## **Ann Machado - 1150 Brighton Ave. - Permit #2014-00478**

**From:** Ann Machado  
**To:** kpatel@maine.rr.com  
**Date:** 3/19/2014 8:17 AM  
**Subject:** 1150 Brighton Ave. - Permit #2014-00478

# 200 Front Desk

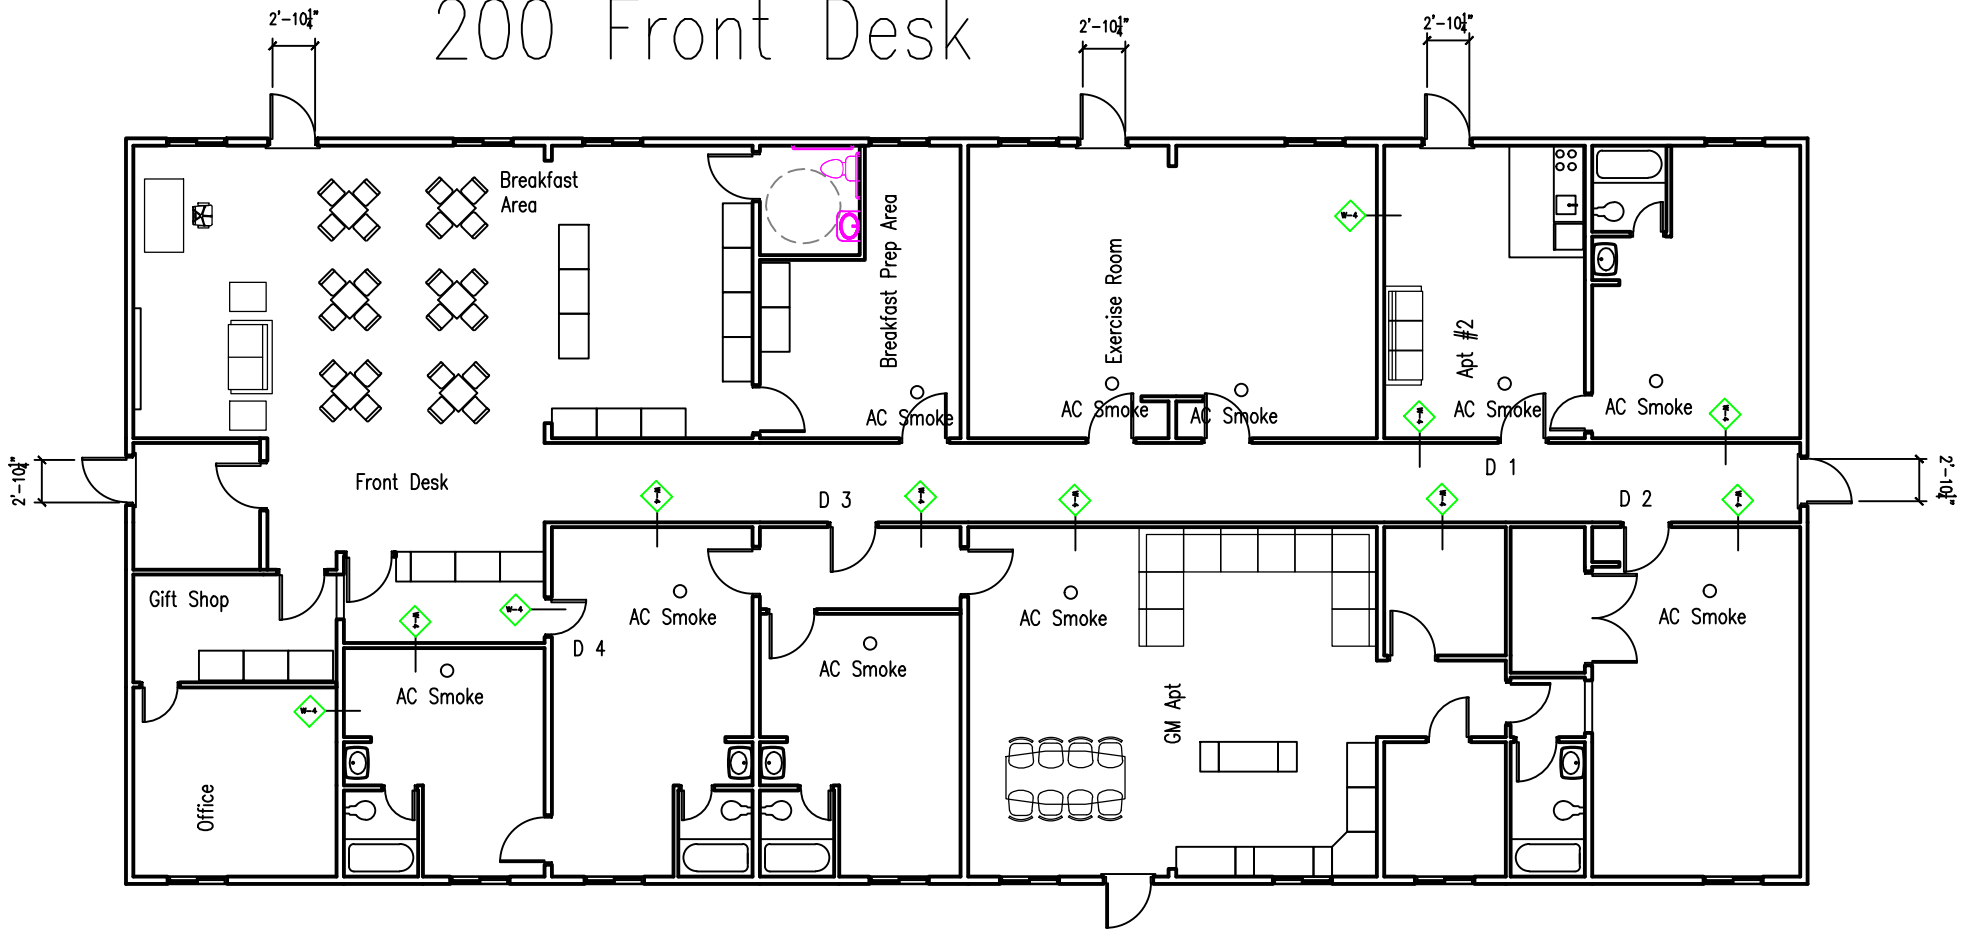
1. Is Building 200 a one or two story building? If it is a two story building is the change of use on the first floor?
2. I need more clarification on the two apartments. You label one as GM apartment. Is this apartment for the general manager? How is the second apartment going to be used?
3. I understand that you are doing work on building 200. You also submitted roof framing plans for building 100, 300 and 400. Is this work also part of the permit? What exactly is being done to these roofs? This should be part of the project description.
